June 24, 2015

RE: 118 Congress Street Dog Wash Area

SKA.85c

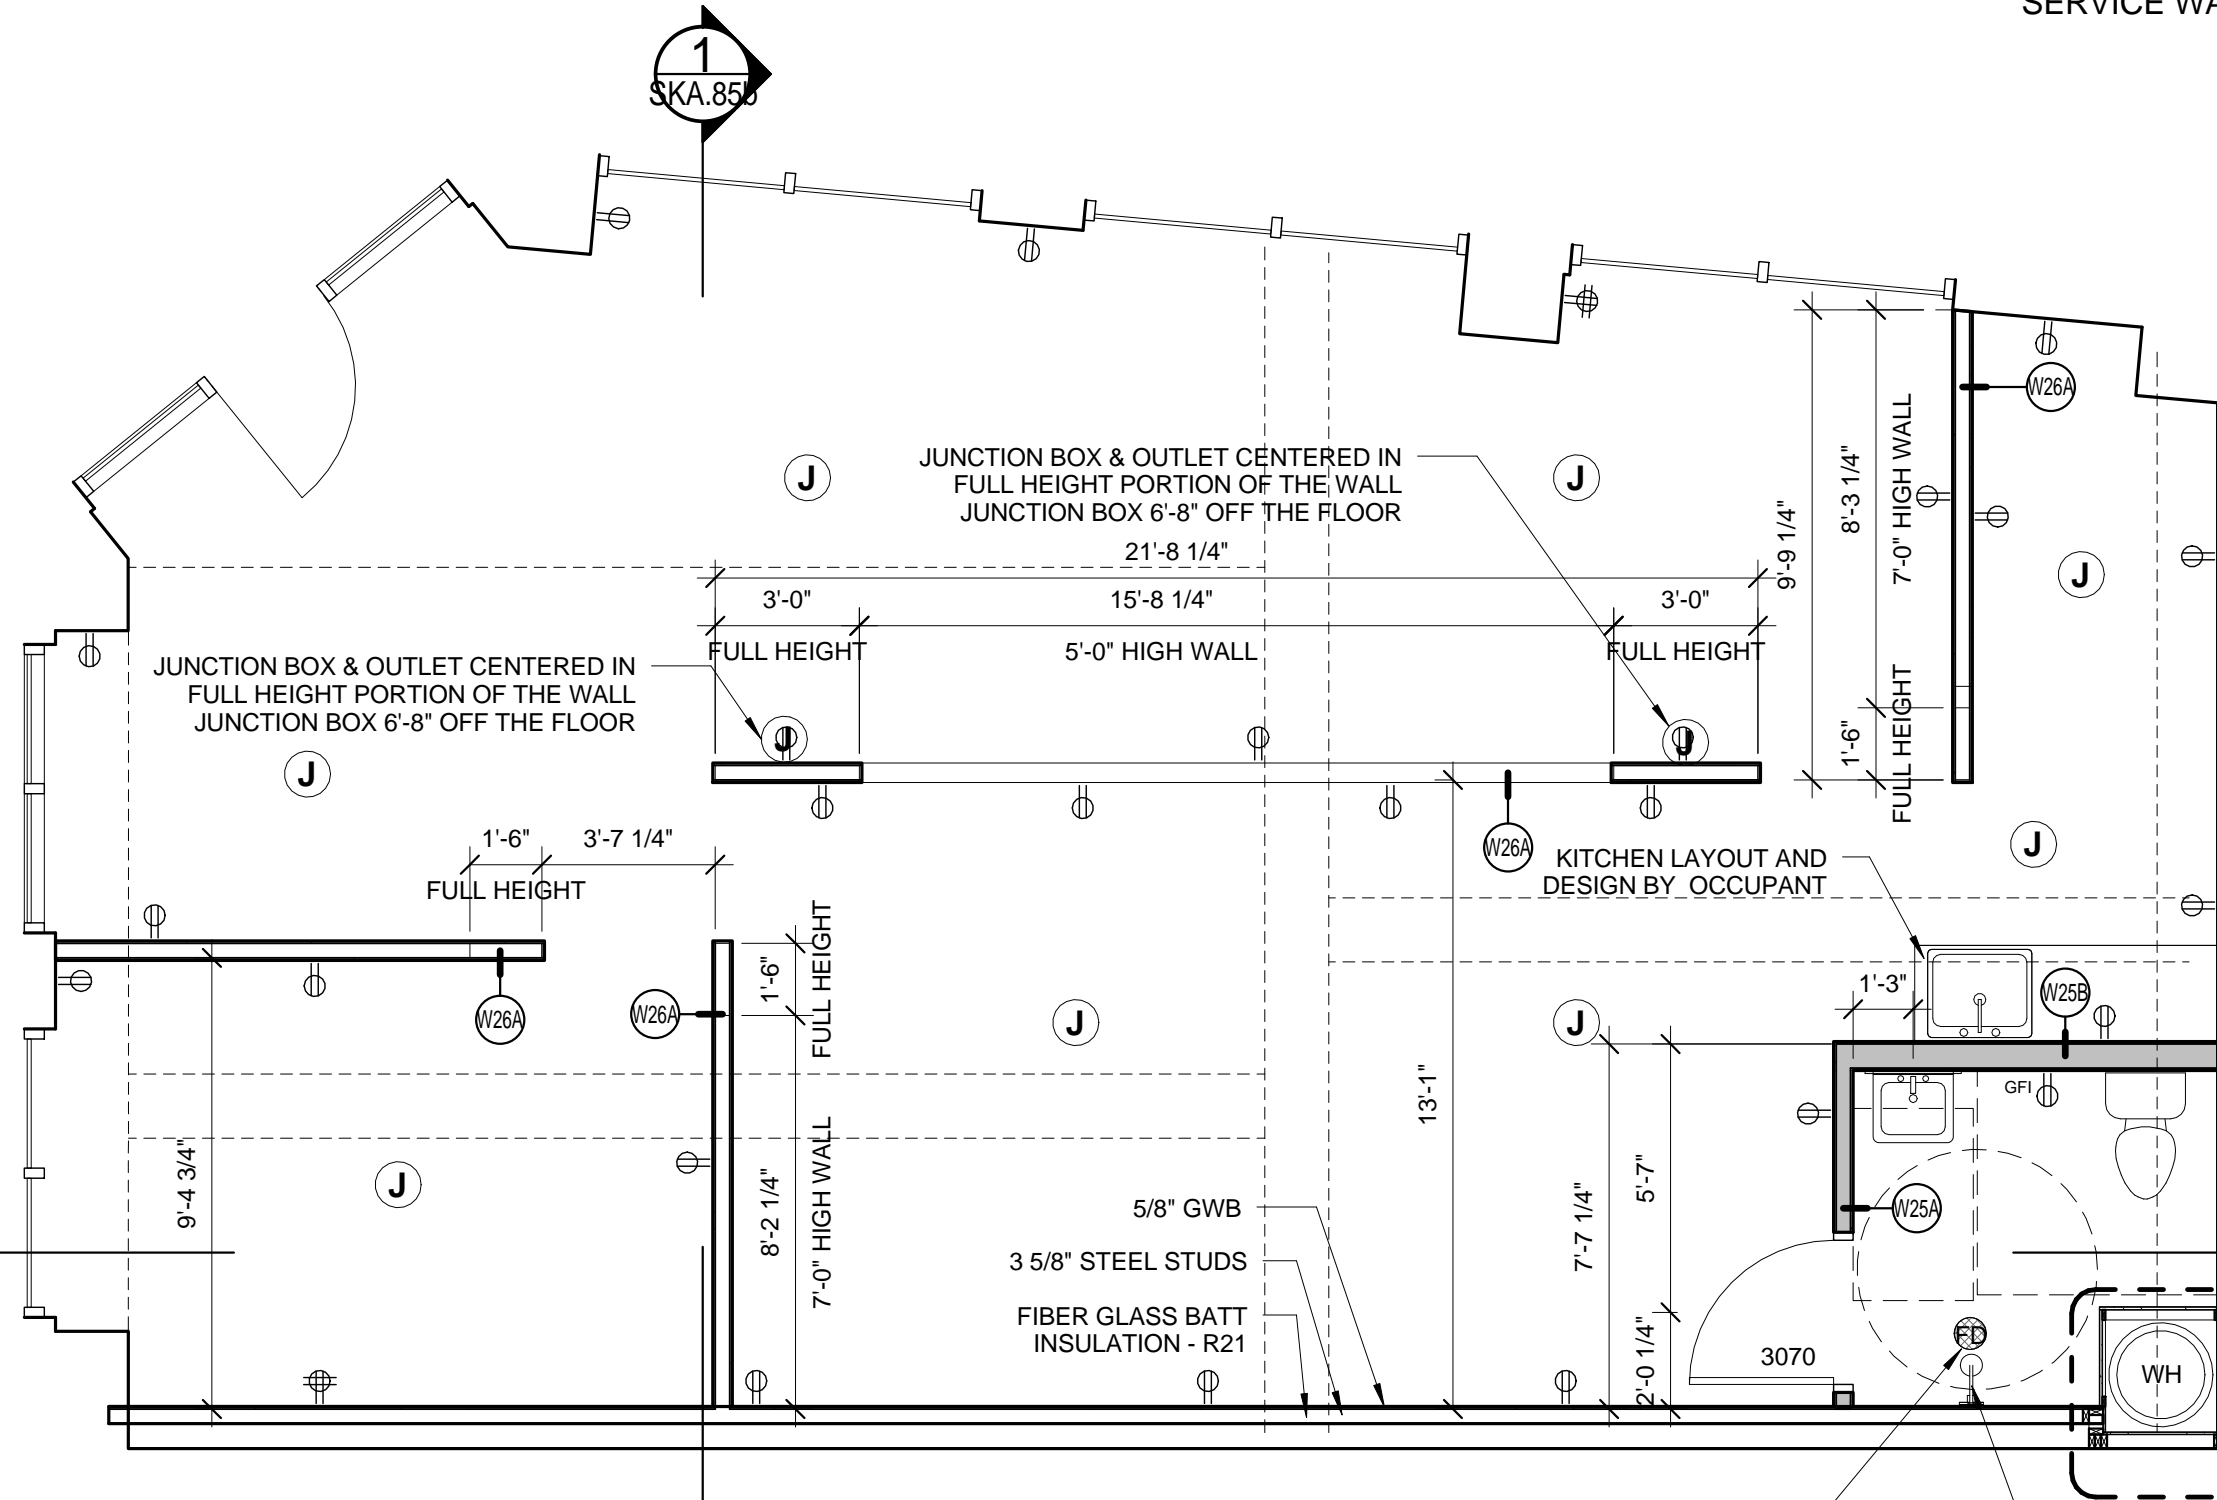
Please remove the heater from the dog wash area and all electrical conduit associated with this work. We understand that Portland Code Enforcement is not comfortable with the spray water feature and the electric heater in the same space. We are not concerned that this space will be below freezing and cause ice problems.
